PROJECT: Botley West Solar Farm (BWSF) — Application Ref: EN010142

I am writing as a registered Interested Party and the homeowner of Pelican House to submit this formal objection to the Development Consent Order (DCO) application for the proposed Botley West Solar Farm (BWSF).

1. Factually Misleading Visual Assessments: The Case of Pelican House (Figure 2.26)

Figure 3 - Central Area Masterplan Changes Animation

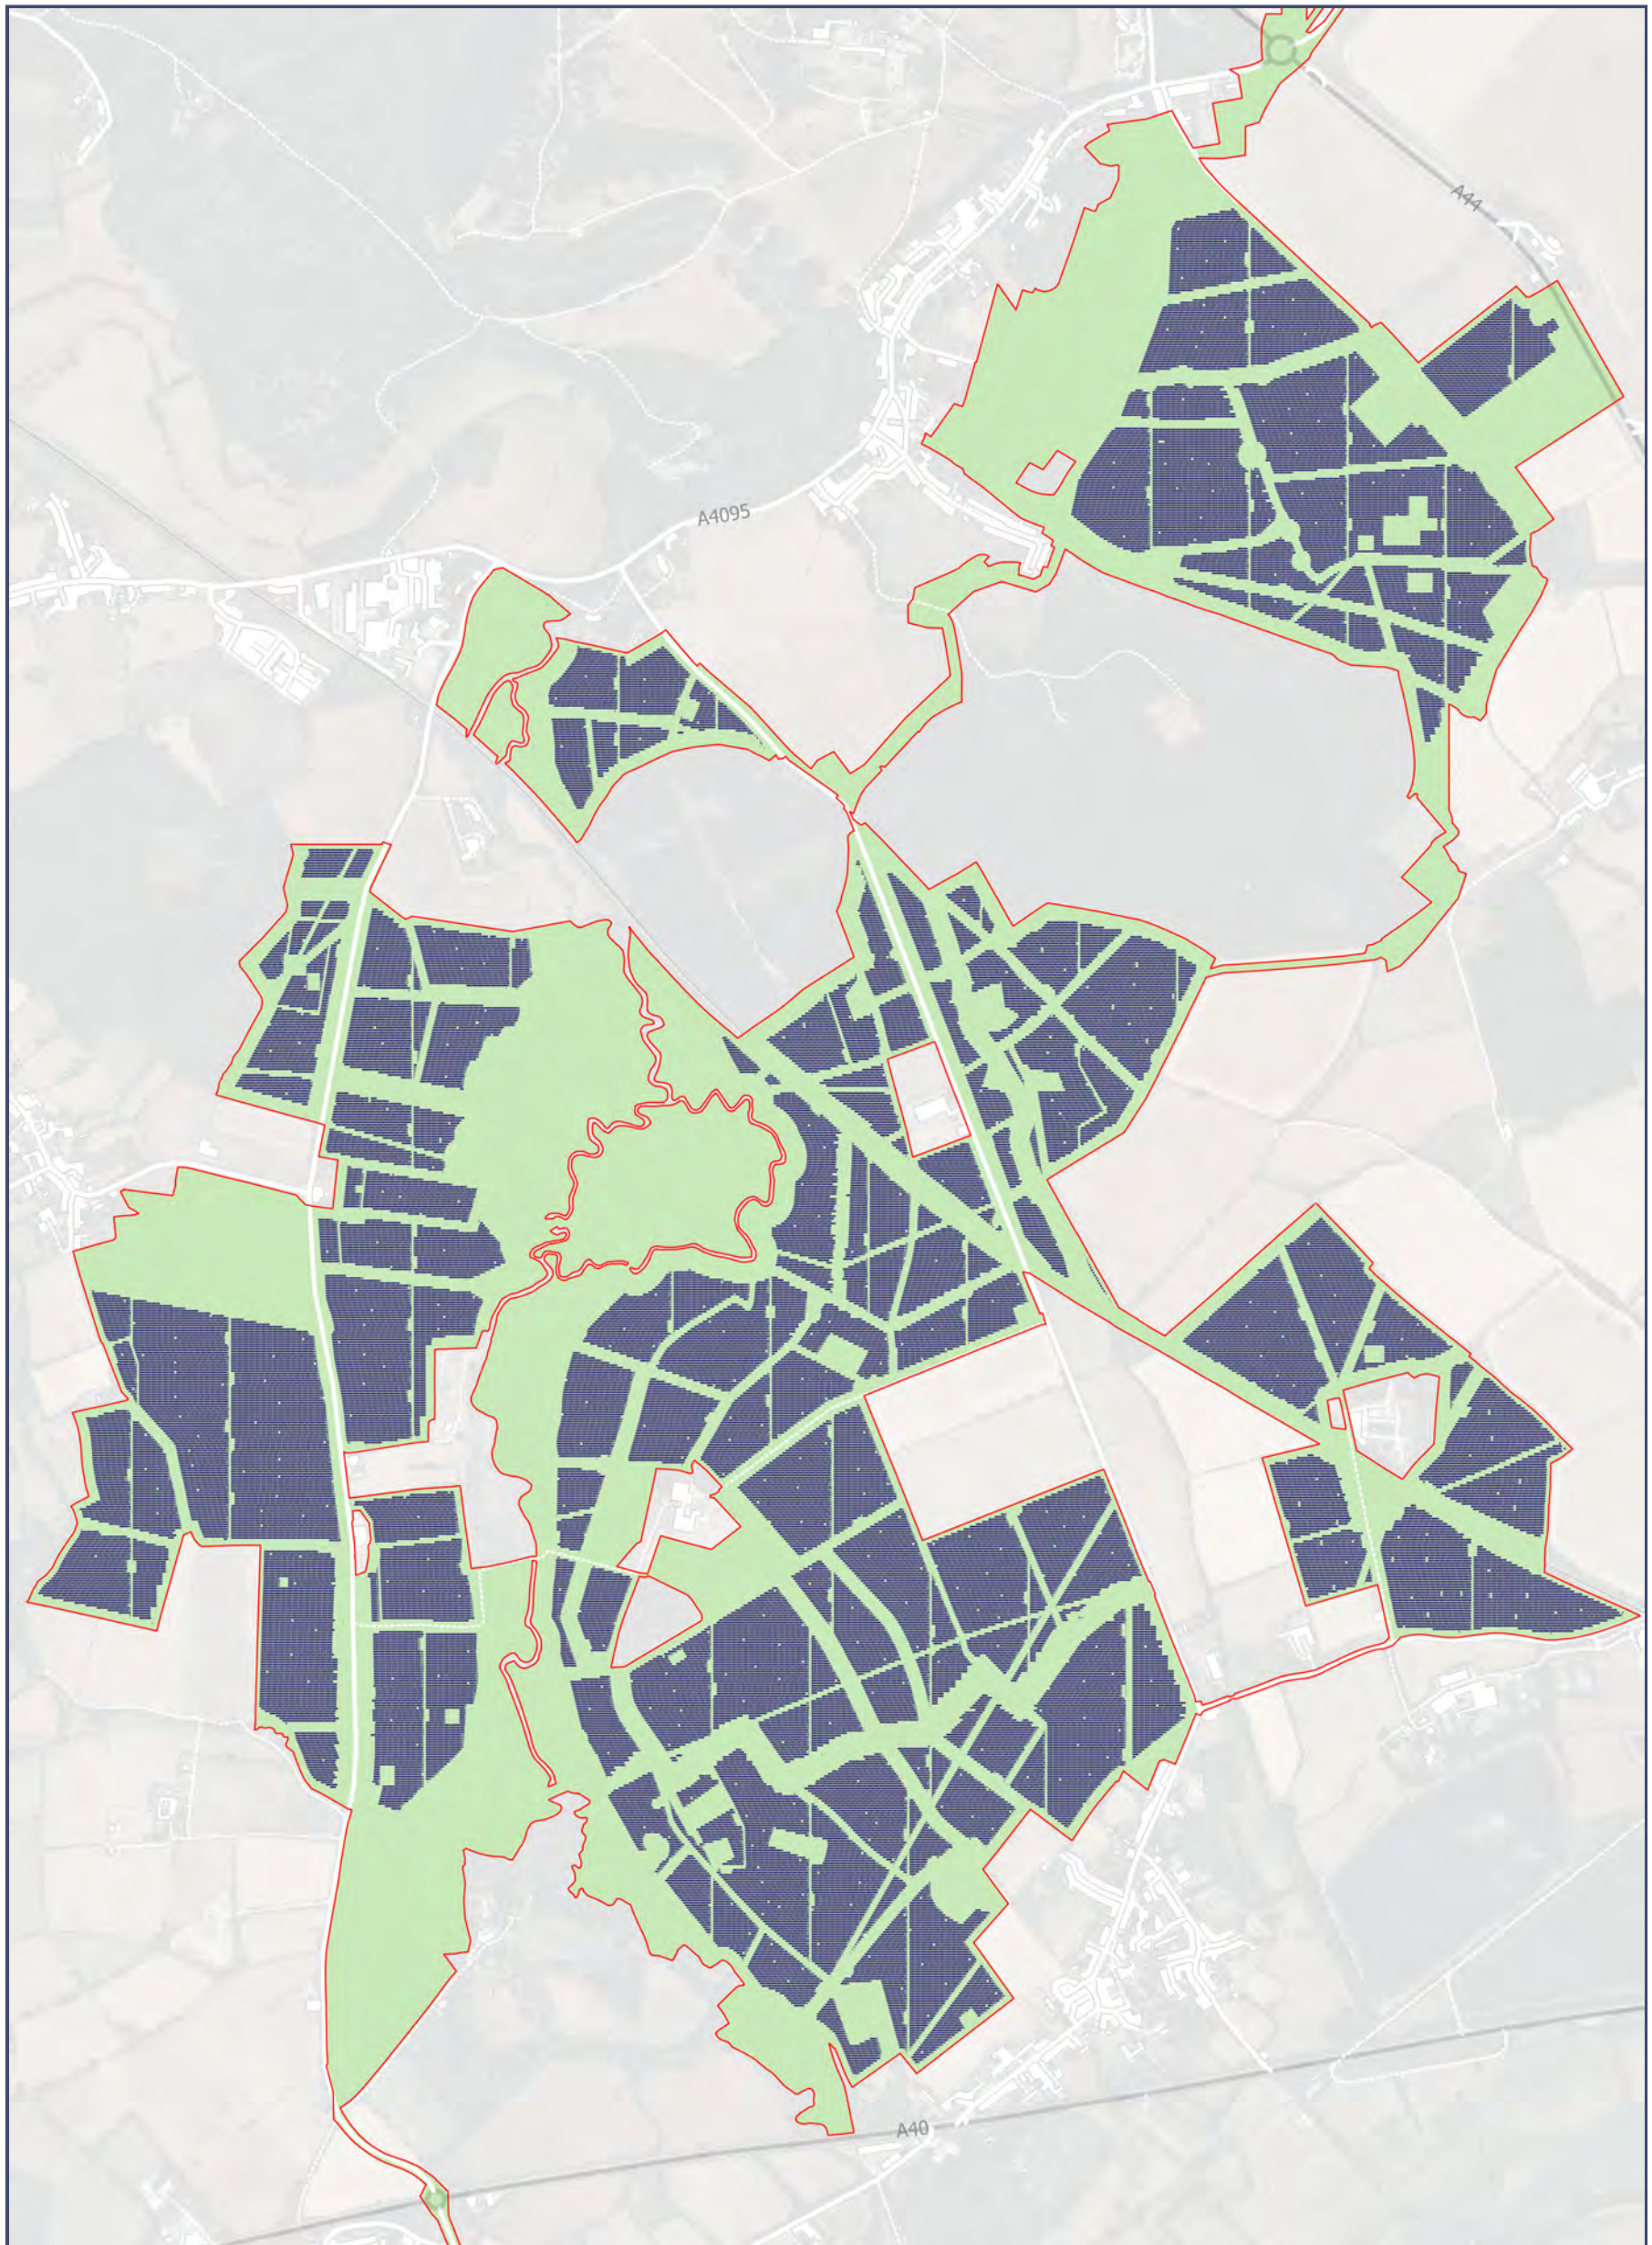
"The house is 50m to the west of the solar panels in the central section of the Project Site. It appears that views of the solar panels would be partially screened by the hedgerow and trees along the eastern perimeter of the property. Views of the solar panels 100m to the north and 80m to the south of the house would be screened by the vegetation which surrounds the property. There would be more distant views, from upper floors to solar panels on rising ground to the east on the Evenlode Valley sides."

A residential separation distance of a mere 50 metres from a massive industrial solar array represents a catastrophic visual intrusion. Standard domestic perimeter hedges and seasonal garden trees cannot mitigate or "screen" an asset of this scale.

Furthermore, the Applicant's photography deliberately ignores the vertical reality of the site: our upper-floor windows look directly over the top of existing garden vegetation, offering unobstructed, dominant views of the solar panels sprawling across the rising ground of the Evenlode Valley to the east. The photography has been selectively angled and framed to fabricate an illusion of complete screening, intentionally downplaying the true damage to our residential visual amenity.

The Applicant's revised masterplans represent a deliberate obfuscation of this requirement:

- **Enforcement of Substandard Buffers:** While trying to present an appearance of compliance, the Applicant is actually seeking to enforce a minimum buffer of just 100m. In the case of Pelican House, the proposed separation is an even more egregious 50 metres, directly violating acceptable planning parameters.
- **Democratic and Procedural Evasion:** The Applicant proposes to defer the final decisions on buffer boundaries until *after* the DCO is granted, leaving them to be finalised privately with local authorities. This mechanism is profoundly undemocratic, as it denies Interested Parties their statutory right to consult on final site layouts. Furthermore, it is entirely unworkable; local authorities have already stated clearly on the record that they lack the time, resources, and technical expertise to handle these complex micro-siting decisions post-consent.
